**CITY OF ALBUQUERQUE  
PLANNING DEPARTMENT  
Development Review Board  
June 2, 2004  
Comments**

**PROJECT # 1003460**

**RE: Lots 6 & 7, Snow Hgts Add./sketch**

REQUEST FOR: Sketch Plat  
(lot line adjustment)

PLAT OF  
LOTS 6-A AND 7-A, BLOCK 37  
SNOW HEIGHTS ADDITION

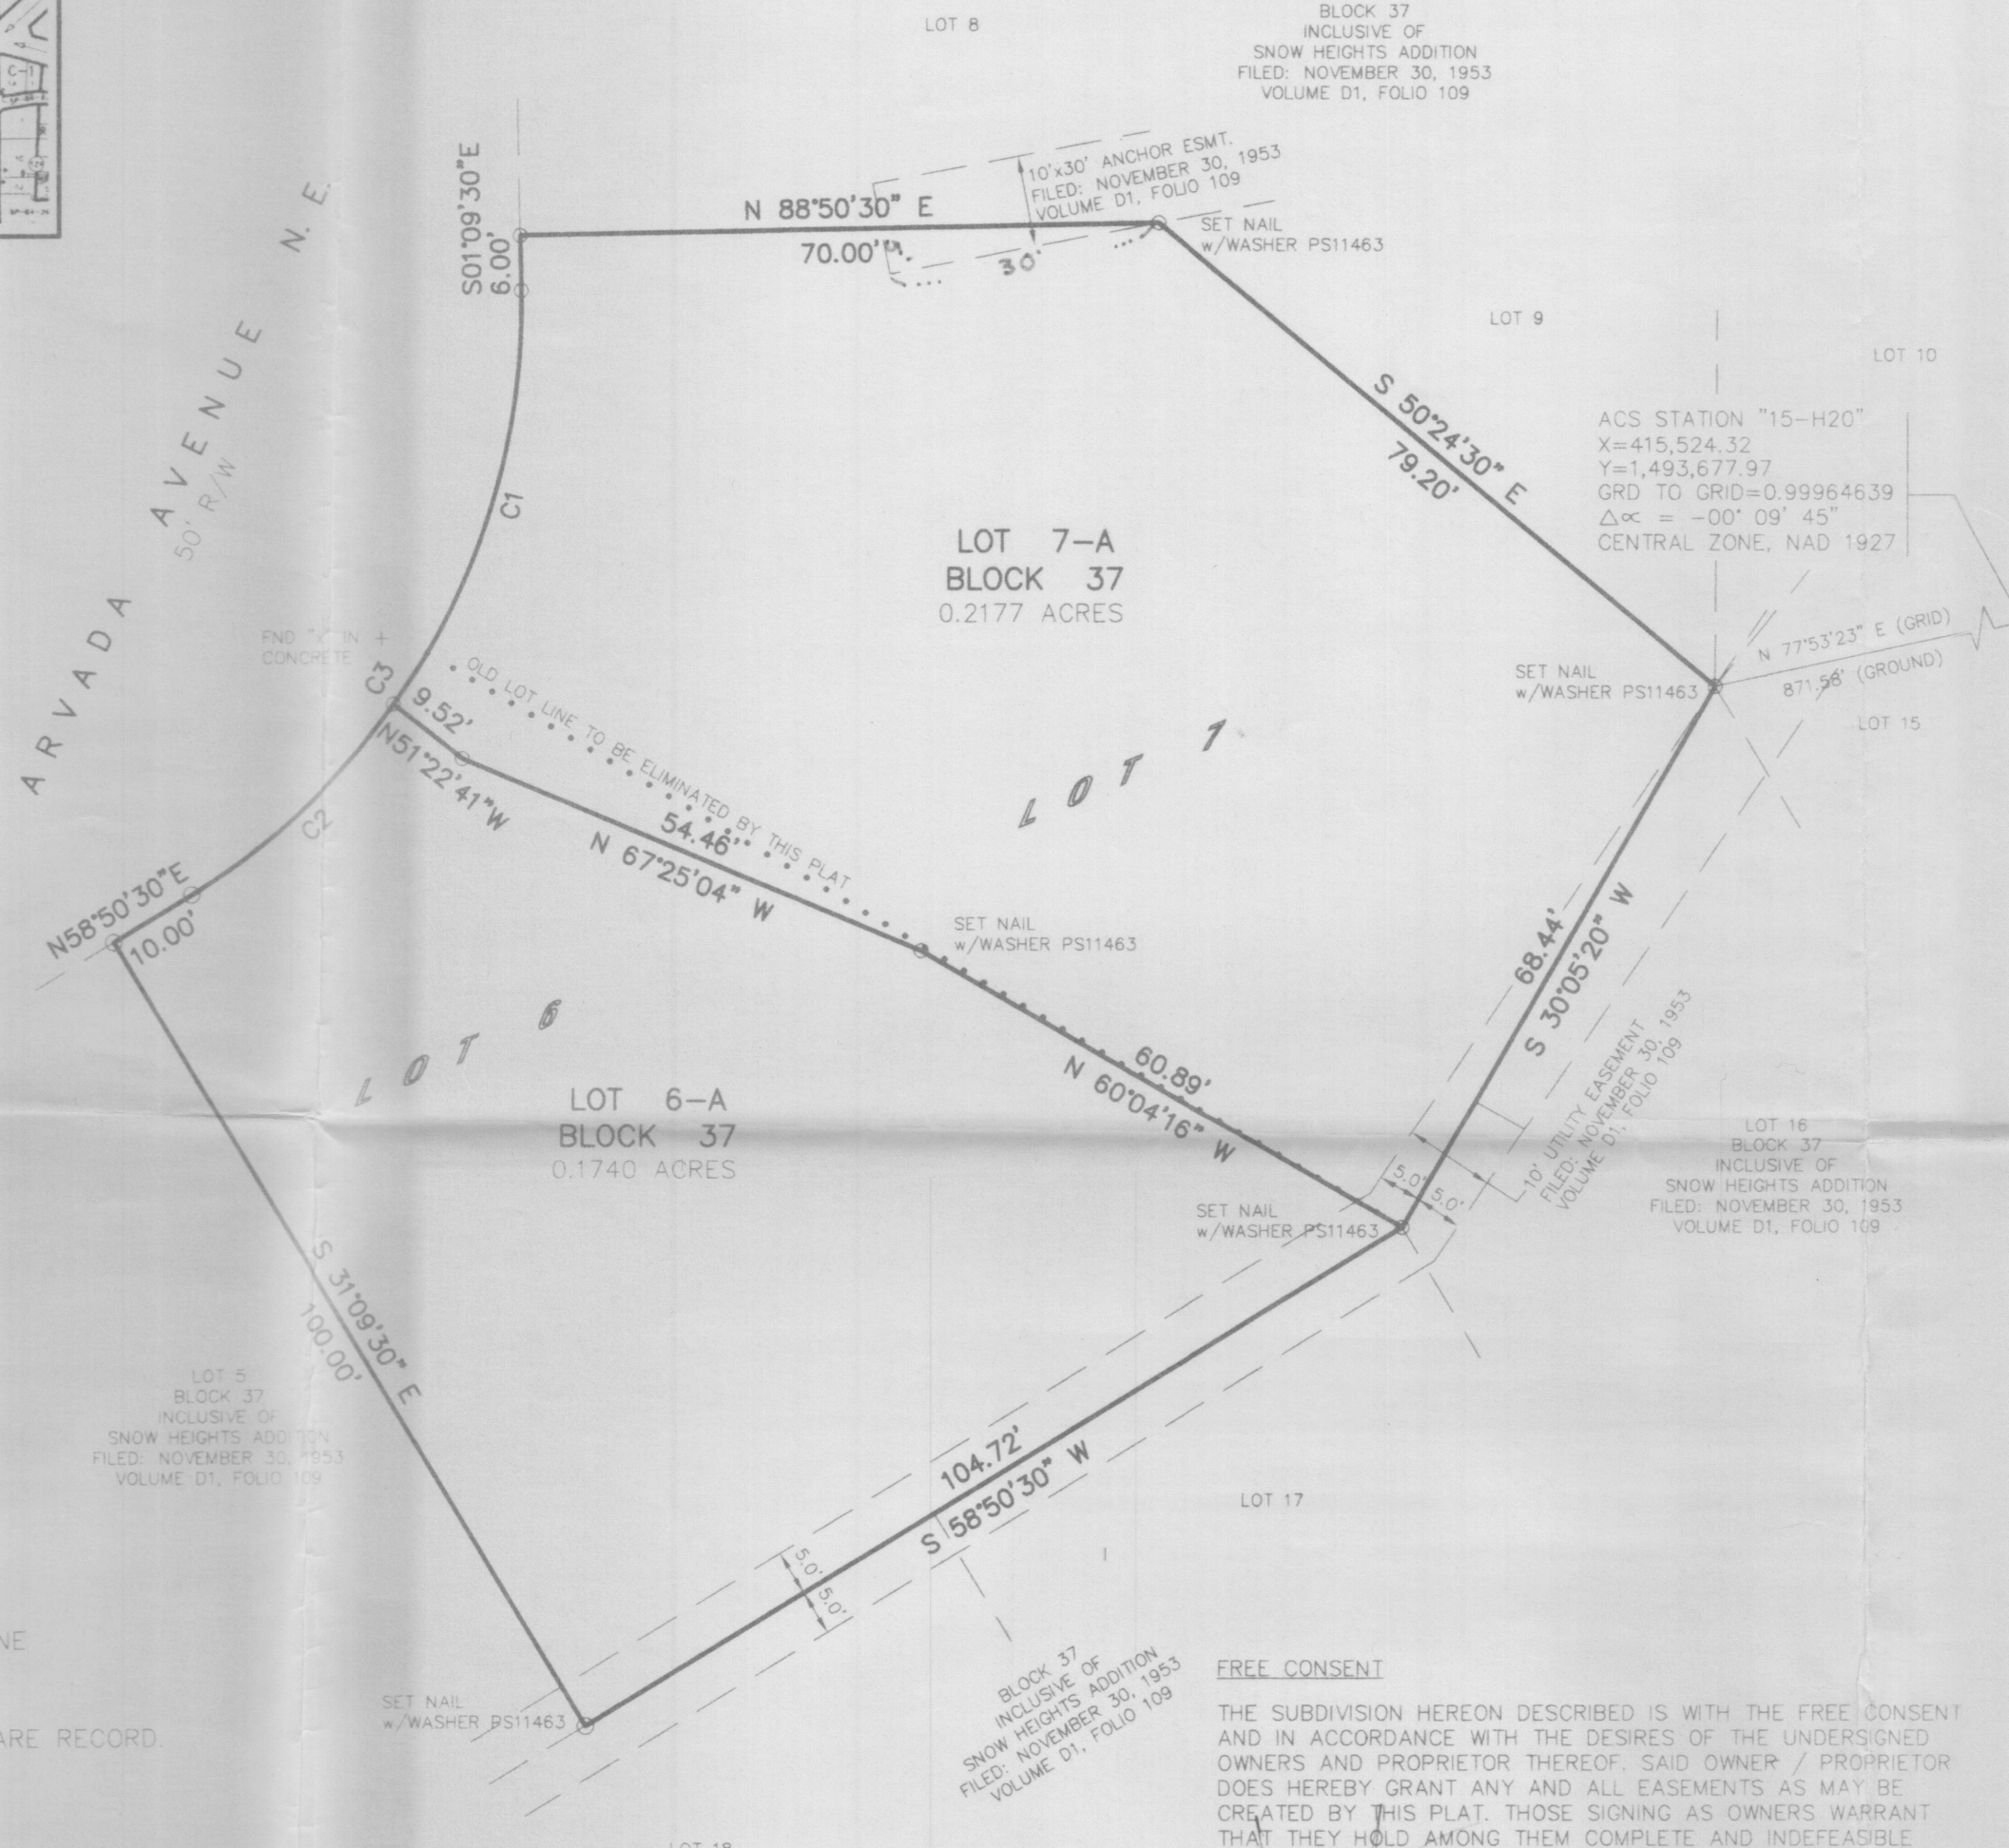
1. Where is the water meter? Typically a single meter box housing 2 meters is located on the lot line.
2. No meter boxes may be located in drive pads.
3. May need private easements if service lines are affected within the affected area.

- 1) Will the current curb cuts be used or are modifications proposed?
- 2) No adverse comment.
